**From:** [Mau, Russell E \(DOH\)](#)  
**To:** [Kelly Bacon \(CD\)](#)  
**Cc:** [DOH EPH DW ERO ADMIN](#); [Smits, Brenda M \(DOH\)](#); [Hayden, Kathryn E \(DOH\)](#); [Holly Erdman](#); [Darian Osiadacz](#); [Darian Osiadacz](#)  
**Subject:** RE: LP-22-00001 Suncadia Phase 2 Division 7 - Notice of Application; Suncadia Resort, AA317E, Kittitas County  
**Date:** Friday, February 11, 2022 7:41:25 AM

The Department of Health (DOH) Office of Drinking Water (ODW) has the following comments:

SUNCADIA RESORT LLC
 PHASE 2 DIVISION 7
 COMPOSITE UTILITY PLAN
 WASHINGTON

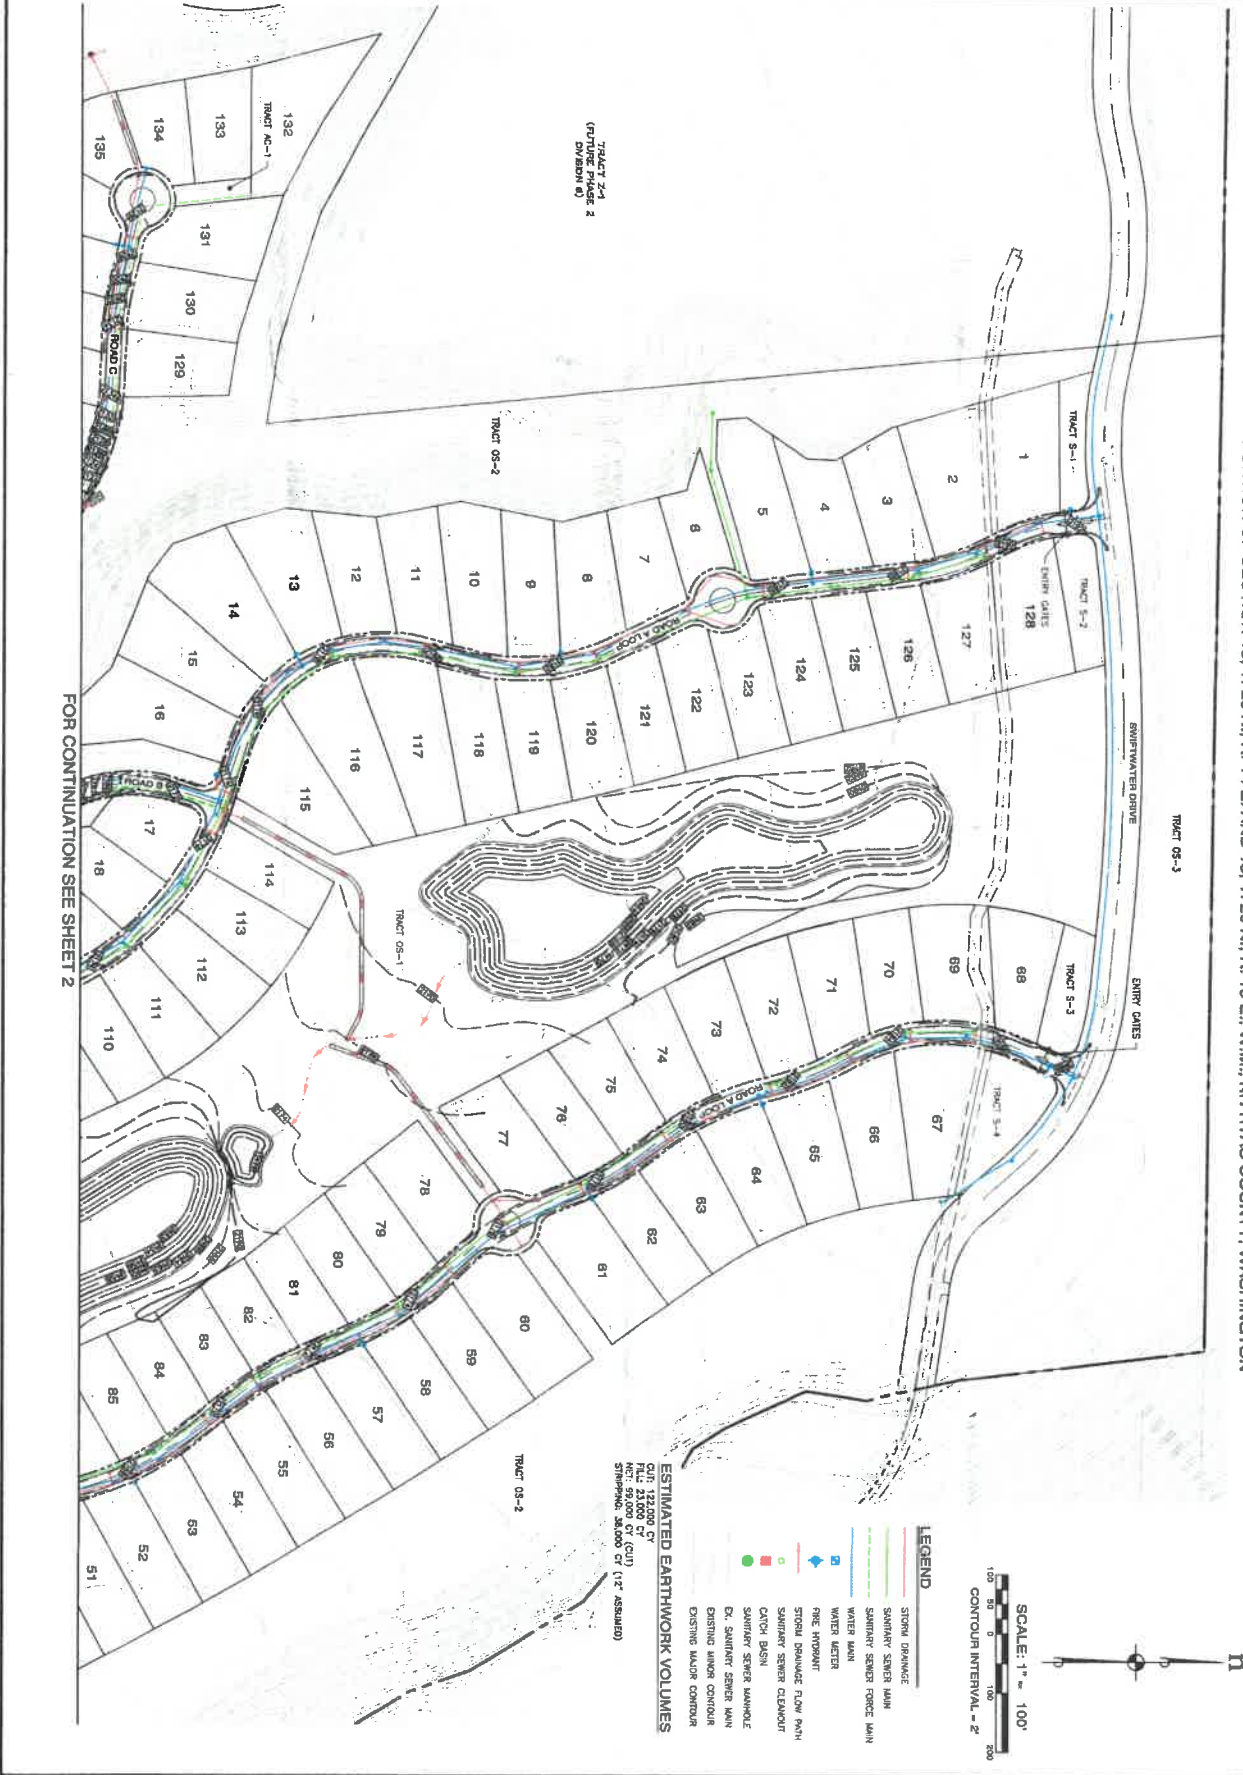
- To serve these connections, and all other proposed connections that are “in development” at this time based on the recent or semi-recent similar applications, Suncadia does need to have a Professional Engineer evaluate and design distribution piping that can convey necessary Peak Hour flow rates while maintaining required pressures throughout the distribution system at all existing and newly constructed connections.
- As the recent or semi-recently proposed connections are constructed (a total of 369 new connections), Suncadia does need to update their WFI to show these as active connections.
- With 140 remaining available connections, DOH feels that as the 369 new connections are constructed and actively receive water, Suncadia should re-assess their capacity and capacity limits to serve drinking water to their customers.
